REQUEST

Current Zoning: N1-A (neighborhood 1 – A)
Proposed Zoning: UR-2(CD) (urban residential, conditional)

The petition proposes to allow a 14-unit townhome development on a vacant parcel located between Park Road and Wintercrest Lane and on the north side of Fairview Road.

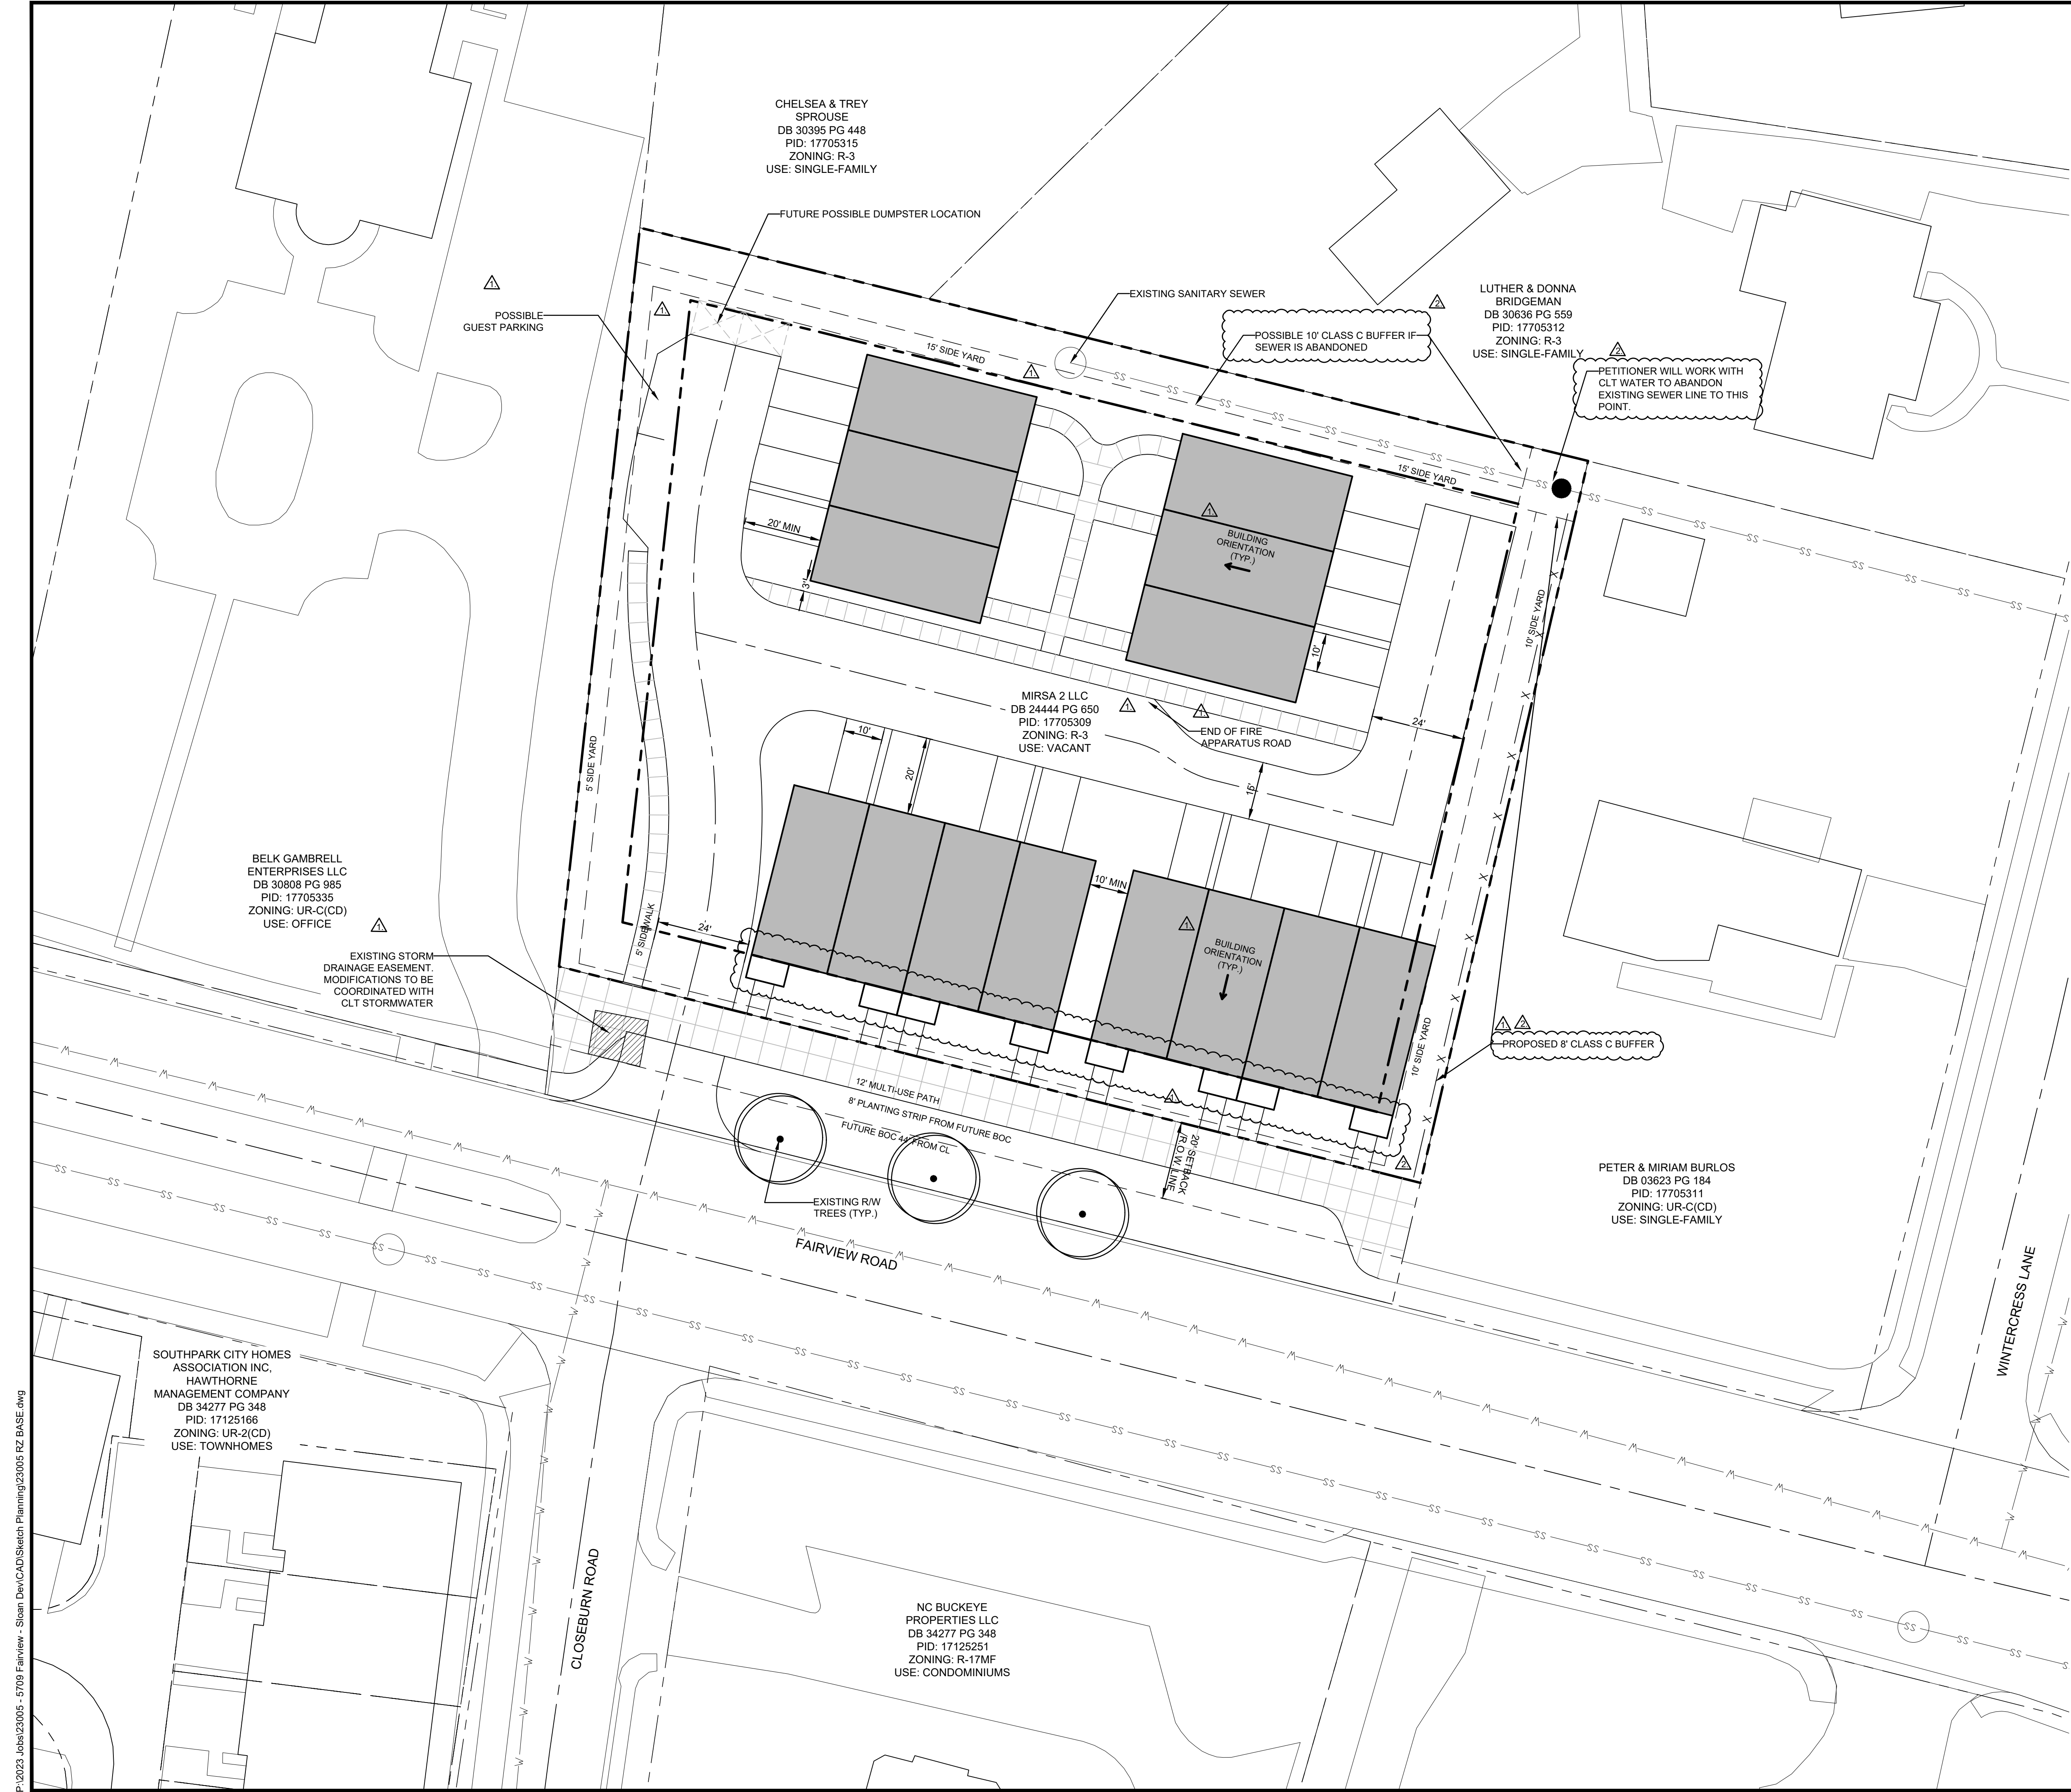
OUTSTANDING ISSUESSite and Building Design

1. Limit the building height to 45 feet.
2. Proposed eight-foot Class C buffer along east property line should be increased to 10 feet with language included it will not be reduced by 25%.

3. Amend Architectural Standards Note 4 to read "The units along Fairview Road shall provide a porch or stoop facing Fairview Road." The 400 square feet of private open space will be required by the ordinance anyway, so that language can be removed.

4. Amend language to Limit the number of dwelling units in one building to four when fronting Fairview Road.
5. The site plan shows a 15-foot sanitary sewer main line that runs parallel to a portion of the north property line. The petitioner needs to show and label the actual width of the sanitary sewer easement on the site plan. Provide a minimum 10-foot Class C buffer outside the sanitary sewer easement along the north property line. Show and label the buffer on the site plan and commit to this improvement in the development notes, specifying to not be reduced by 25%.
